FURTHER RESPONSE TO FRA.

LAND NORTH OF FORMER TILBURY POWER STATION, TILBURY, ESSEX

Thank you for your response to our previous comments made in regards to the flood risk for the proposed development of the Thurrock Flexible Generation Plant. The letter dated 21 January 2021, together with the revised Flood Risk Assessment, report reference HLEF 74017, version post-submission rev.1 and dated November 2020, provides clarity on the methodology for the calculation of climate change to account for the both the required UKCP18 update and the H++ scenario.

Flood Evacuation Route

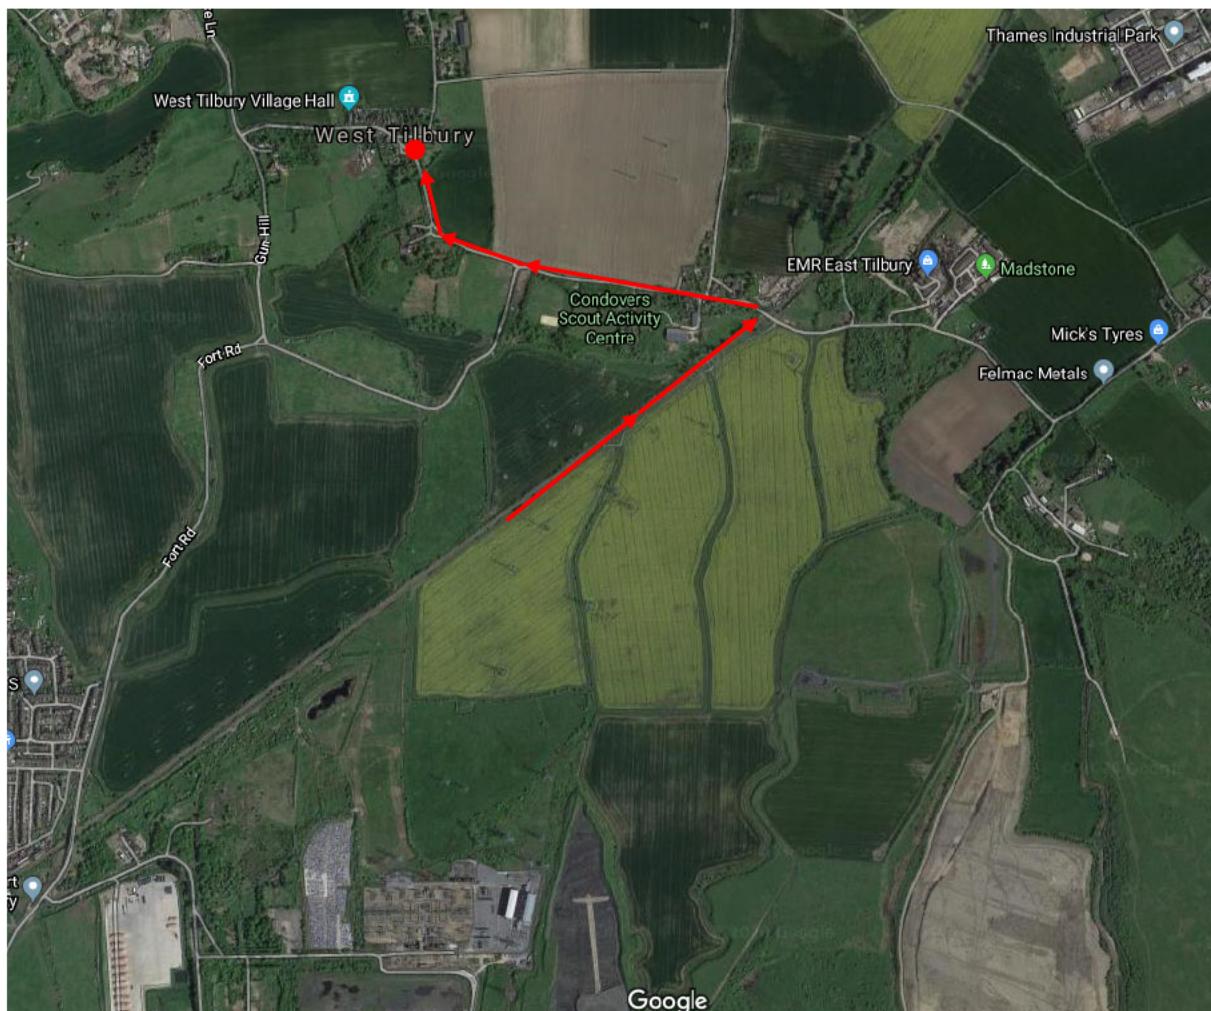
- Any additional non-fixed flood risk mitigation measures e.g. demountable flood barrier, which may be required across the site to reduce the impact of flooding should be clearly detailed within the Flood Evacuation Plan for the site.
- Details of a clear span bridge shall be provided for the crossing at the top of West Tilbury Main as detailed in the letter dated 6 November 2020 to us and Thurrock Council (APP-045 (ES Chapter 2: Project Description)).
